ENG-PUDSP21010-R1-GEC.pdf Markup Summary

GRANDVIEW RESER

EL PASO COUNTY & UTILITY CO

**G1.01**  
Sheet 4 of 14

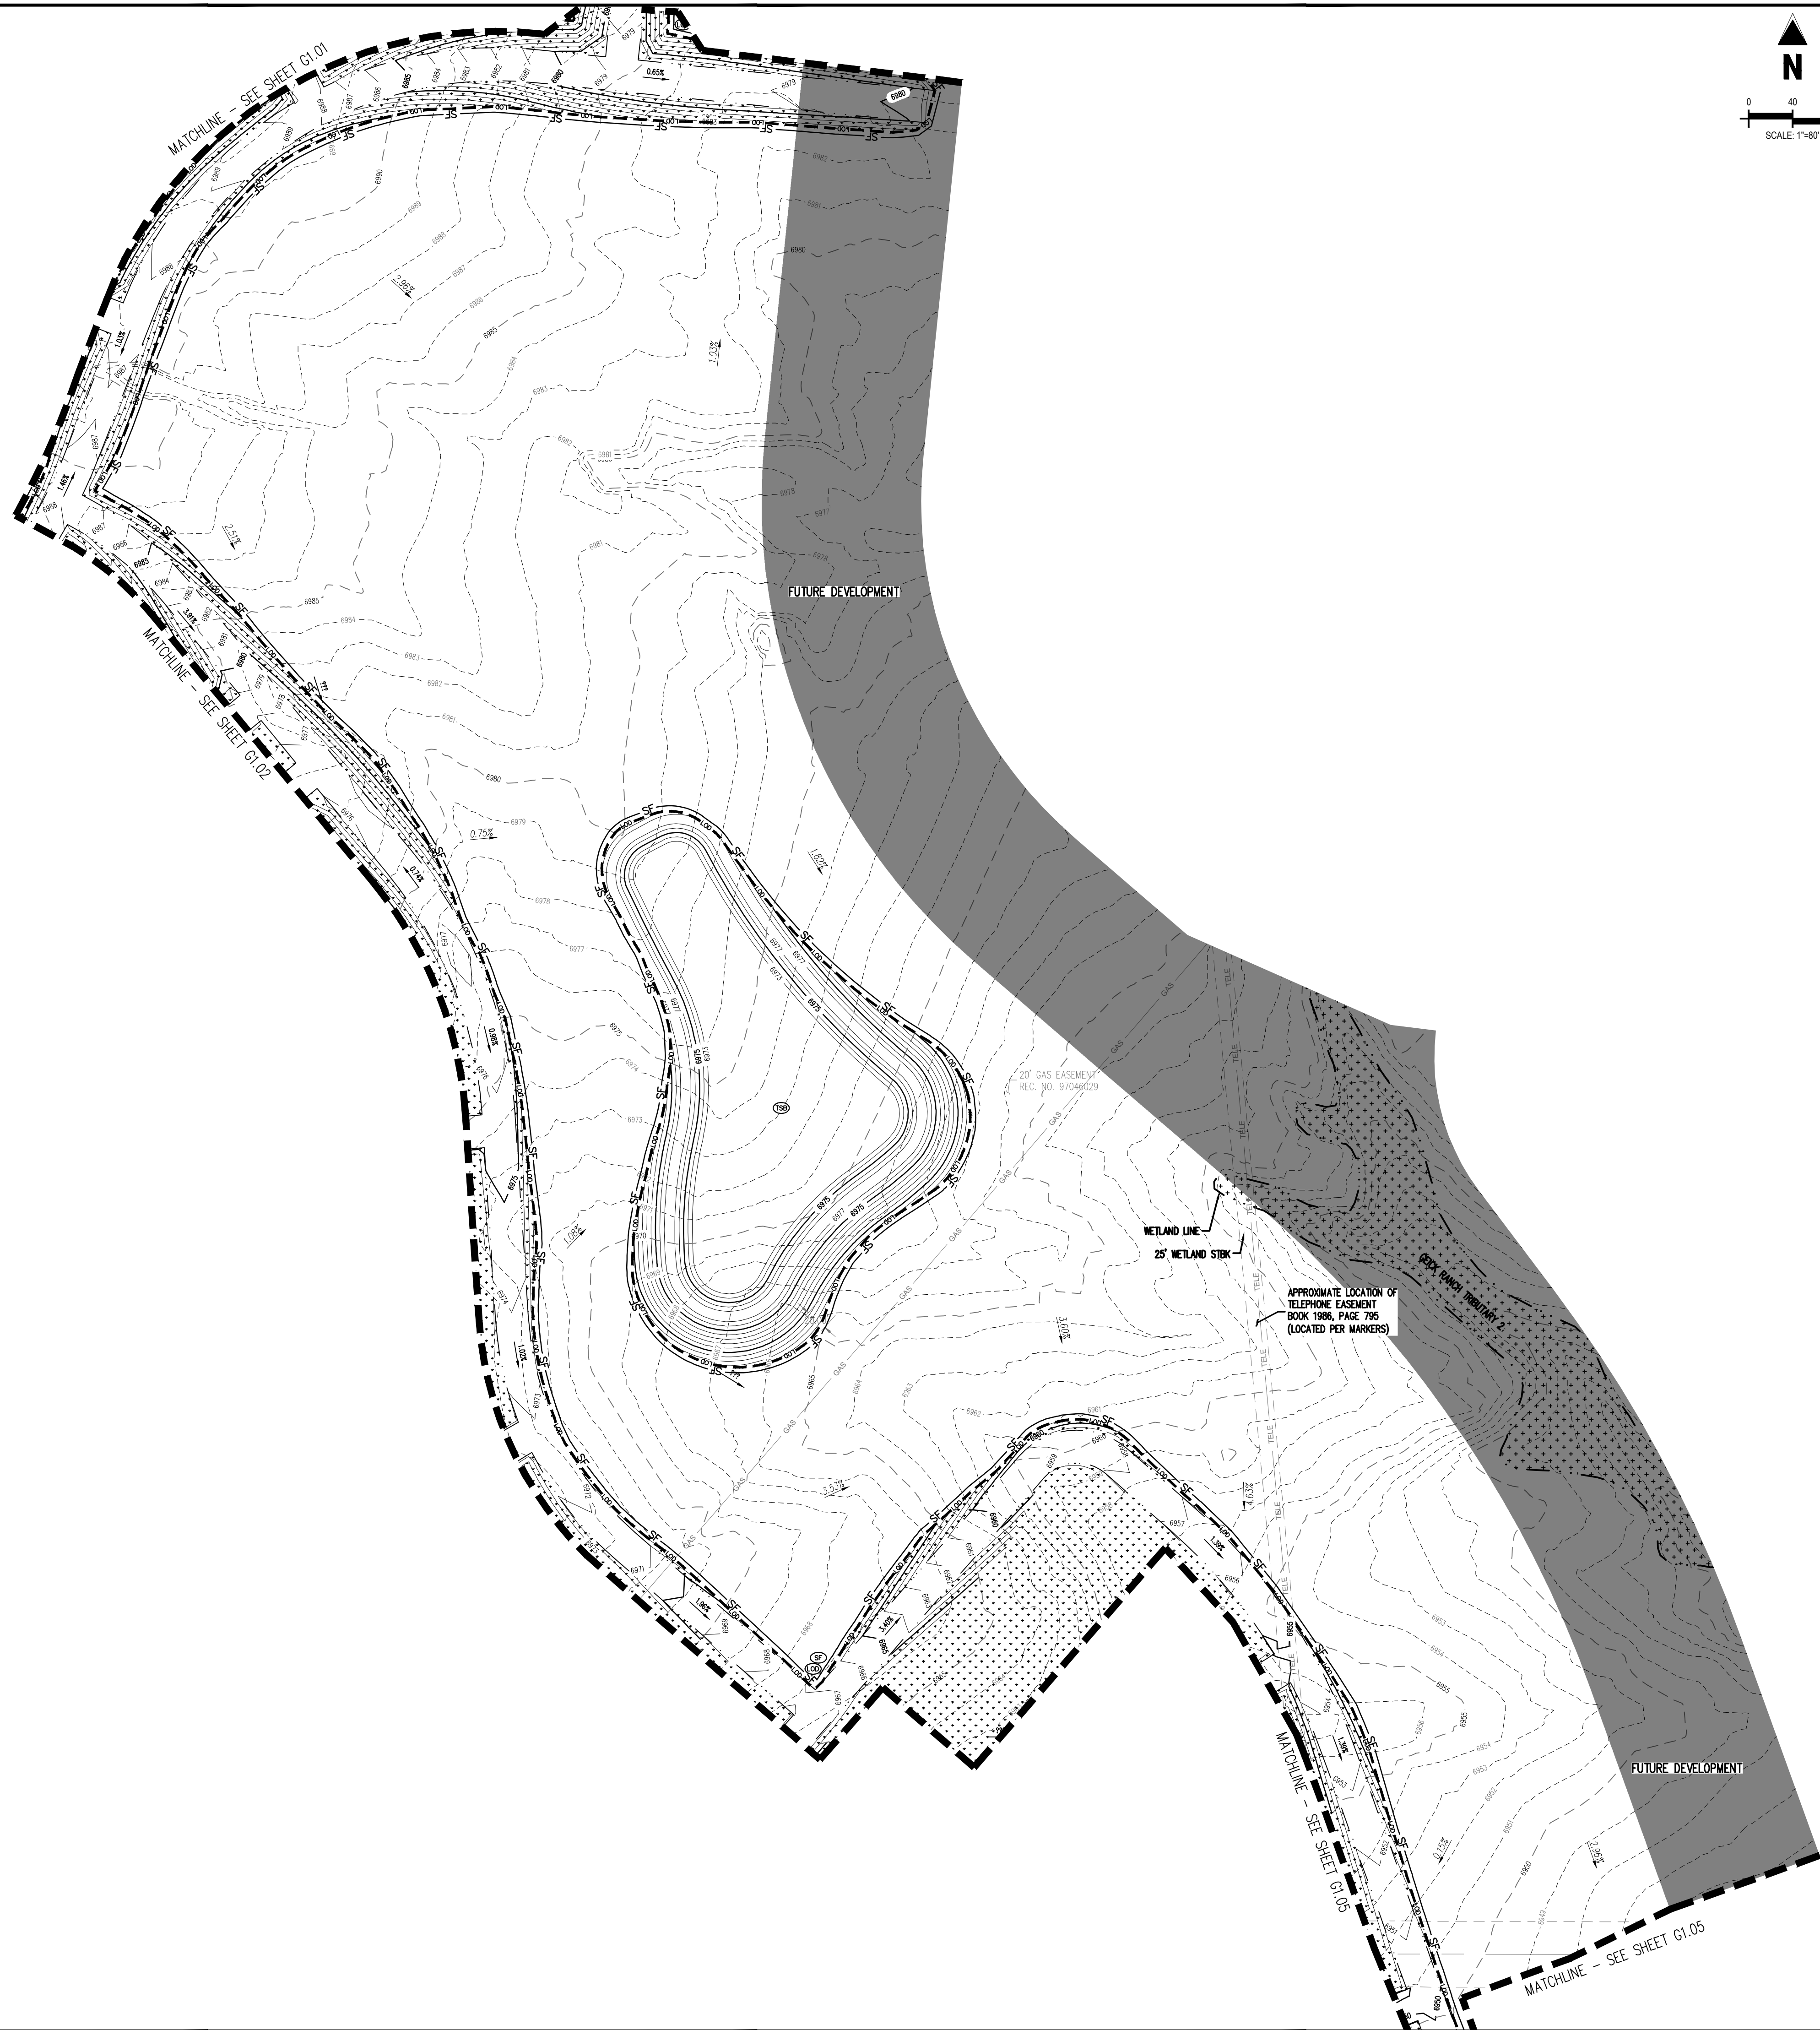
Provide details of temporary sediment basin including riser pipe perforation sizing, number of rows, required volume, location of outlet and spillway, and tributary area to the sediment basin.

Provide details of temporary sediment basin including riser pipe perforation sizing, number of rows, required volume, location of outlet and spillway, and tributary area to the sediment basin.

Provide details of temporary sediment basin including riser pipe perforation sizing, number of rows, required volume, location of outlet and spillway, and tributary area to the sediment basin.

Checklist Item "j" - also show limits of FEMA 100-yr floodplain (typical all plan sheets)

Checklist Item "p" - Delineate areas of cut/fill (typical all plan sheets)

Note that each pond will need it's own easement, which should include the maintenance access road. And each pond will need a maintenance access road.

Offsite easement required.

Provide details of temporary sediment basin including riser pipe perforation sizing, number of rows, required volume, location of outlet and spillway, and tributary area to the sediment basin.

How does flow get to the TSBs?
